CITY OF ALBUQUERQUE

April 11, 2022

Re: Lot 3A-Block 2 @ Metz-Robertson Addn
109 60th St NW
Traffic Circulation Layout
Engineer's Stamp 03-24-2022 (K11-D093)

TRAFFIC  
CIRCULATION PLAN

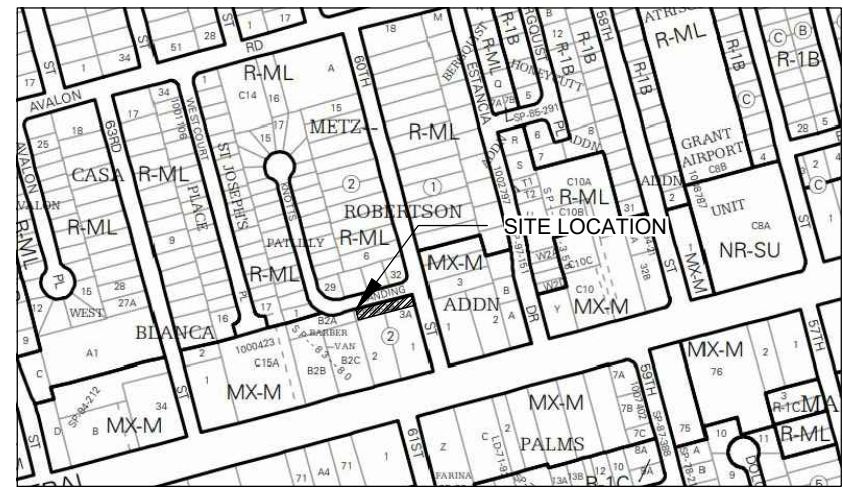
1. Listed are the number of parking spaces required by the IDO as well as the proposed number of parking spaces including bicycle and motorcycle parking.
Coordinate/discuss with Zoning.

2. **Knotts Landing Frontage/Roadway:**
 - Proposed driveway fronting Knotts Landing has a different design from the proposed Work Order? Please clarify.

- Work Order number needs to be provided
 - Please dimension entrance onto site (Need minimum width of 22 ft).
3. **A Condition of Final C.O.:** Work Order must be complete, approved and closeout.

4. **60th Street Frontage:**
 - The roadway surface appears to be temporary. Please verify that if it's temporary or permanent asphalt to determine if a work order will be needed on 60th St. for the roadway surface.

- Proposed sidewalk will need a Sidewalk Easement.
 - You will need adjacent property owner to provide a letter of concurrence for proposed sidewalk on his frontage.

- Explain how you will transition extend sidewalk segment onto proposed driveway without compromising ADA accessibility.
5. All internal radiuses will need to be a minimum 15'R per DPM requirements.

6. The proposed stalls are protruding onto drive aisle. Please adjust.
7. **Overflow Parking Stalls:** parking bumpers will be needed for all stalls.
8. **Keyed Notes 10&11:** Where is your transition from one type to another type for curbing?

9. Clarify the extents of the current phase. Provide a phasing plan.
10. Maximum access width for arterial, collector, and **local streets** are as follows:

12. The ADA accessible spaces must include an access aisle. **Van accessible aisles should be 8ft wide**; all others should be 5ft wide.
13. The ADA access aisles shall have the words "**NO PARKING**" in capital letters, each of which shall be at least one foot high and at least two inches wide, placed at the rear of the parking space so as to be close to where an adjacent vehicle's rear tire would be placed. (66-1-4.1.B NMSA 1978). **PROVIDE DETAIL FOR THE STRIPING AND TEXT (PAVEMENT MARKINGS)**

14. **Motorcycle parking space:** Label pavement MC.
15. All bicycle racks shall be designed according to the following guidelines:
 - a. The rack shall be a minimum 30 inches tall and 18 inches wide.

18. Bicycle parking spaces shall be at least 6 feet long and 2 feet wide.
19. Per the DPM, a 6 ft. wide ADA accessible pedestrian pathway is required from the public sidewalk to the building entrances. Please clearly show this pathway and provide details.

20. Per DPM, a 6 ft. wide ADA accessible pedestrian pathway is required from the ADA parking stall access aisles to the building entrances. Please clearly show this pathway and provide details.

21. All sidewalks along streets should be placed at the property line.
22. It is not apparent what type of pavement surface is being proposed. A hard driving surface will be required as part of this proposed project for parking area and drive aisles.

23. Please provide a sight distance exhibit (**IF APPLICABLE**)
24. Show the clear sight triangle and add the following note to the plan: "Landscaping and signage will not interfere with clear sight requirements. Therefore, signs, walls, trees, and shrubbery between 3 and 8 feet tall (as measured from the gutter pan) will not be acceptable in the clear sight triangle.
